CITY OF ALBUQUERQUE

January 16, 2019

RE: **Lot 3 Block 3 Unit 22 SAD 228**
6328 Camino Alto NW
Volcano Cliffs Subdivision
Grading and Drainage Plan
Engineers Stamp Date; 1/09/19 (D10D003R3)
Pad Certification Date; 1/14/19

ENGINEER'S SEAL	Title 6328 CAMINO ALTO NW	DRAWN BY
	GRADING AND DRAINAGE PLAN	DATE
		Day
		SHEET #
		1 of 1
		JOB #

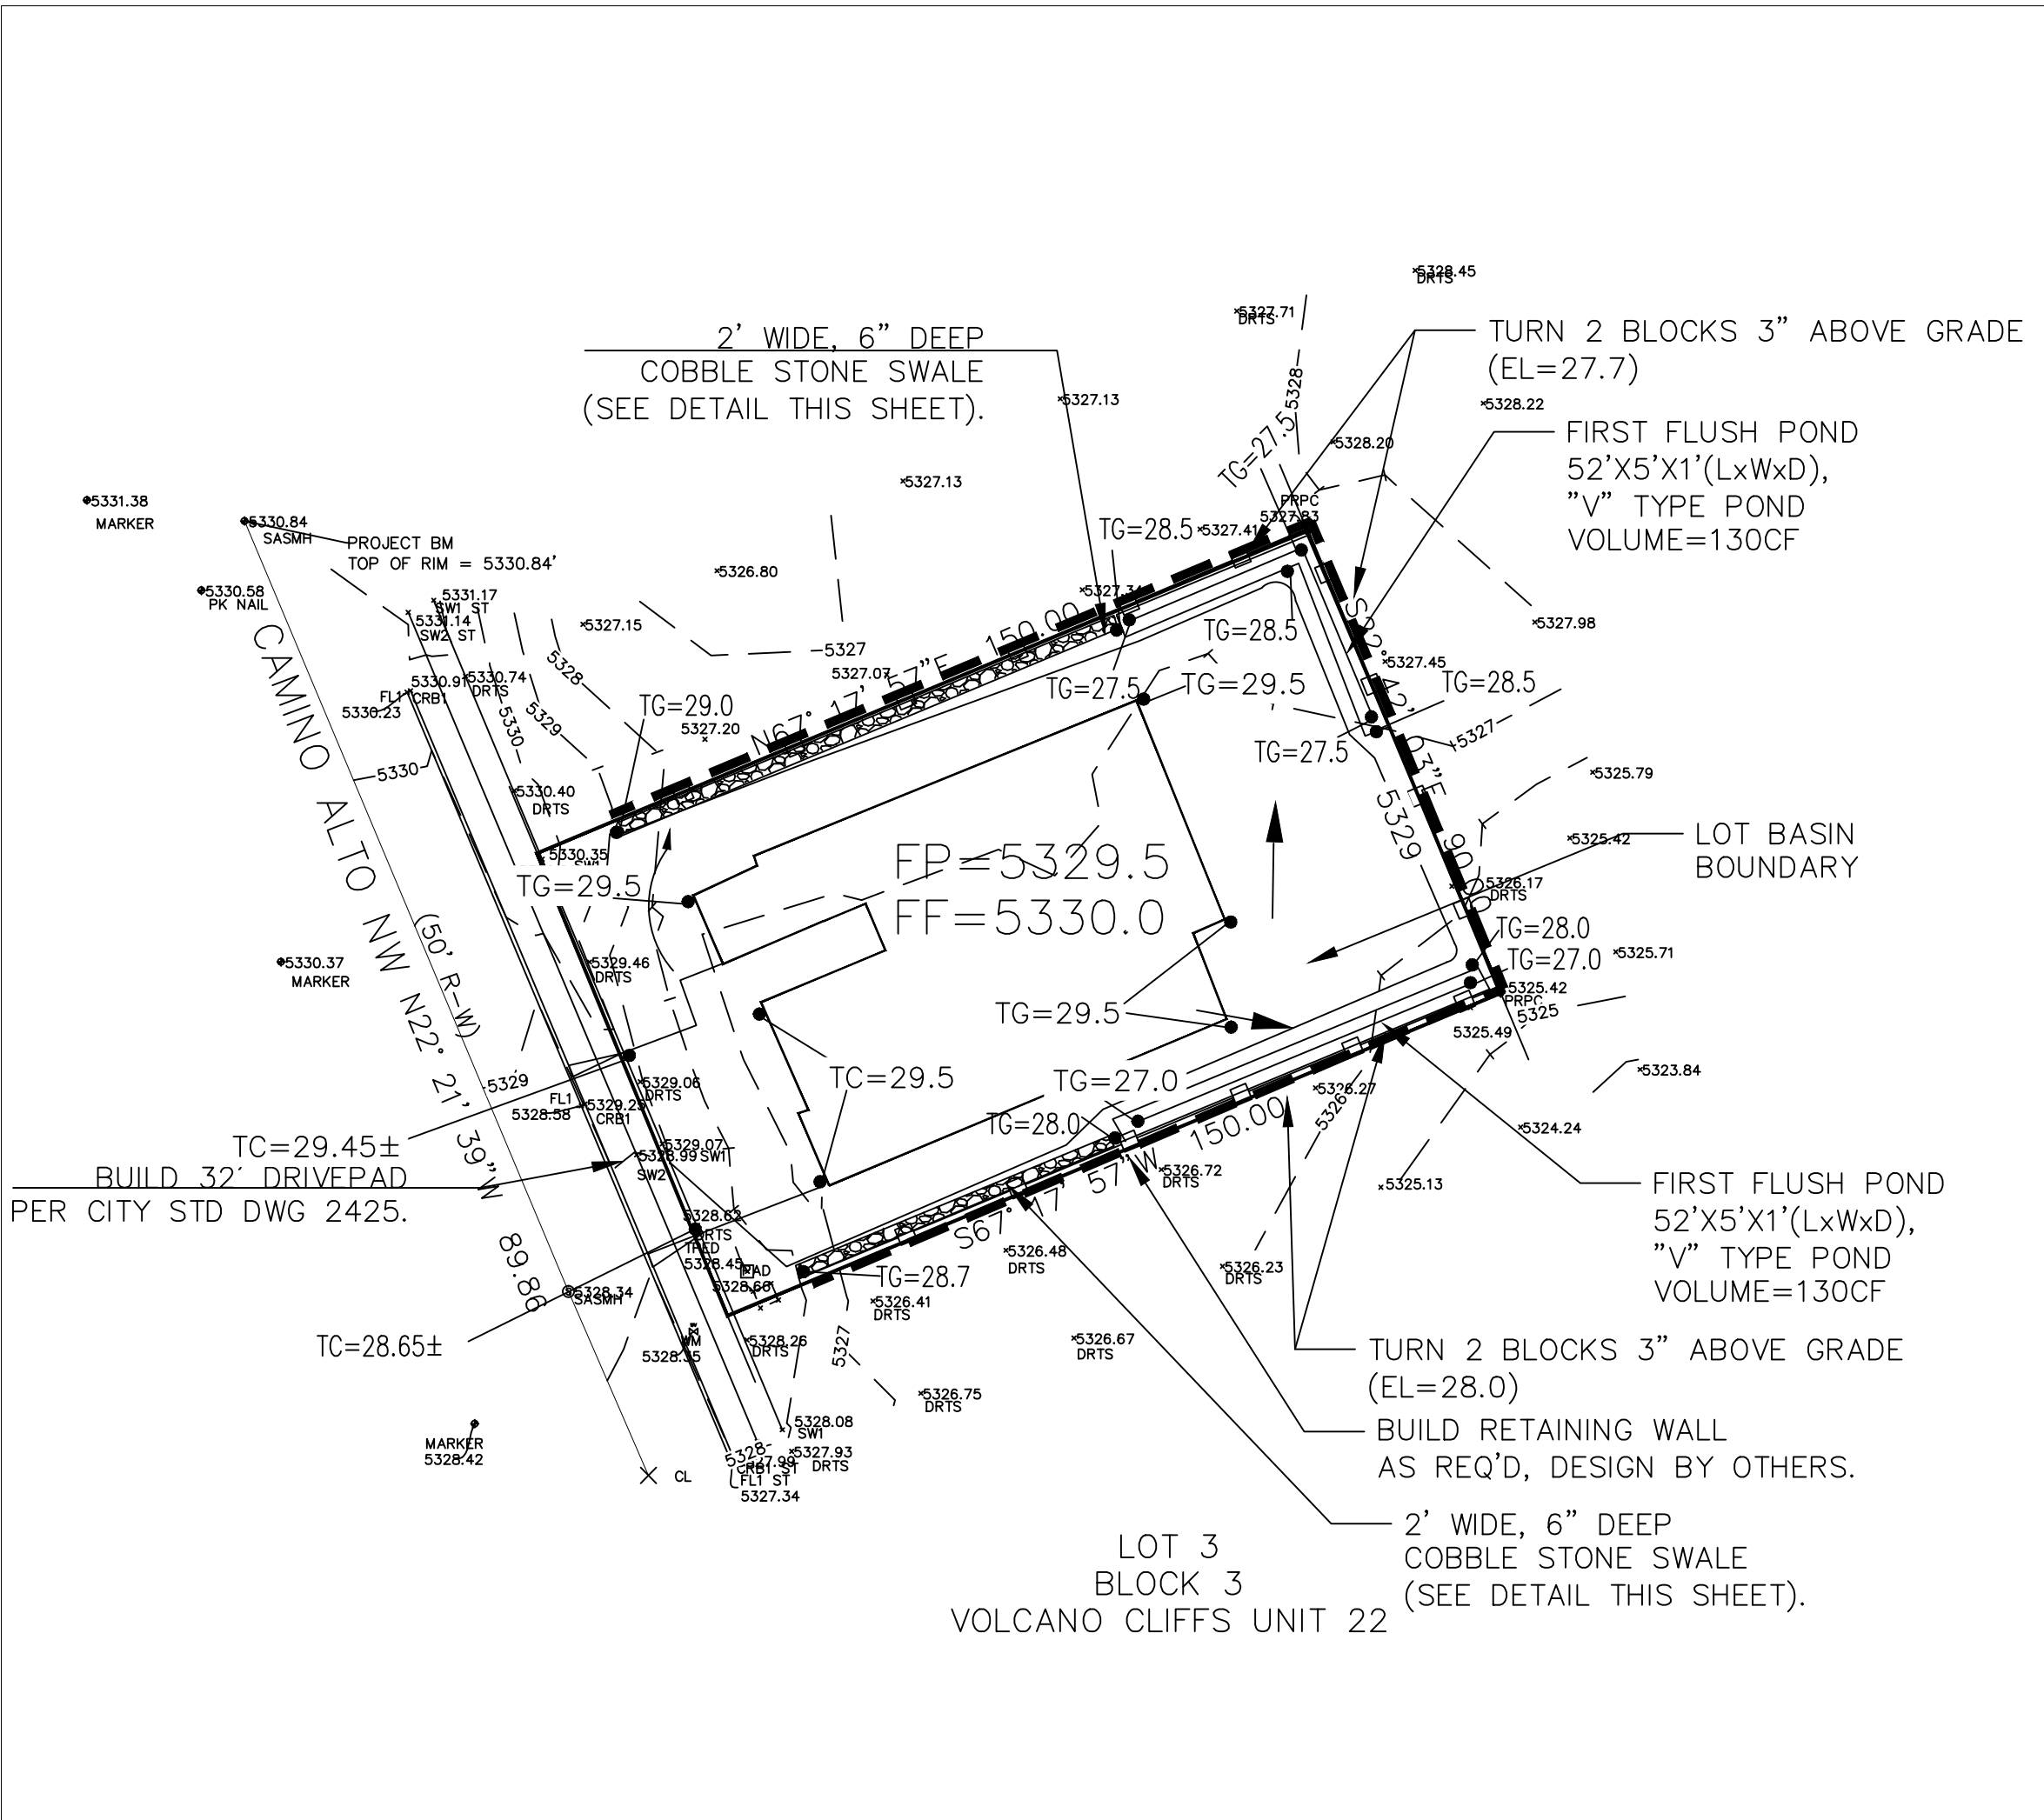
- The original pad is still in place. Remove original pad and place new pad according to plan.
